Planning reference 3/2021/0356:

Location: Wharf Farm, Green Lane, Chipping, PR3 2QE

Proposal: Modernization of agricultural buildings, replacing existing housing - complete dairy unit to accommodate 70 cows

I refer to the letter from the Lead Local Flood Authority dated 10th November 2021.

APPENDIX C

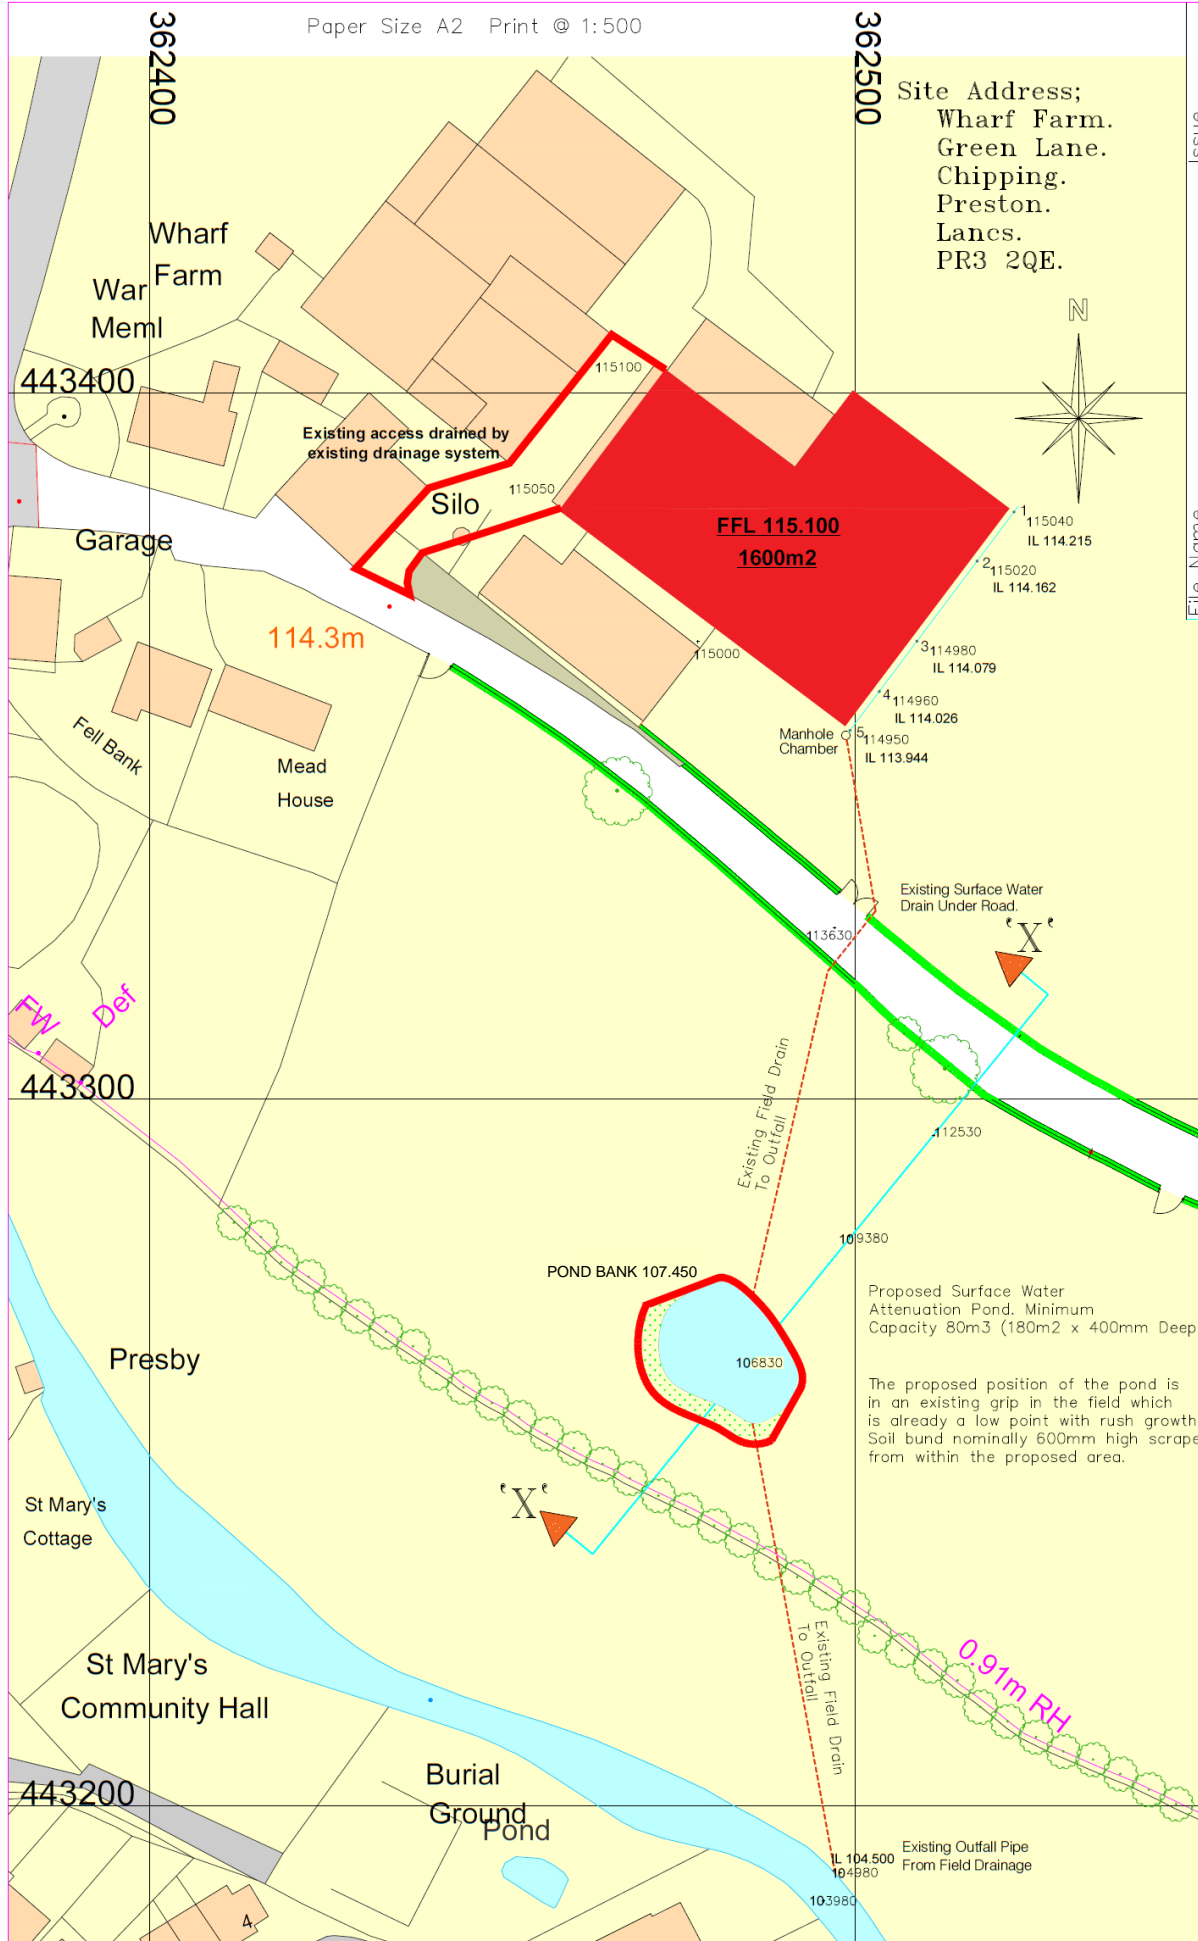
2. Evidence to confirm that a free-flowing outfall can be achieved without backing up or flooding.

A free flowing outfall can be achieved into the pond without backing up or flooding. The design calculations submitted shows that at no time does Node 5 become surcharged. Nor does any flooding from the drainage system occur.
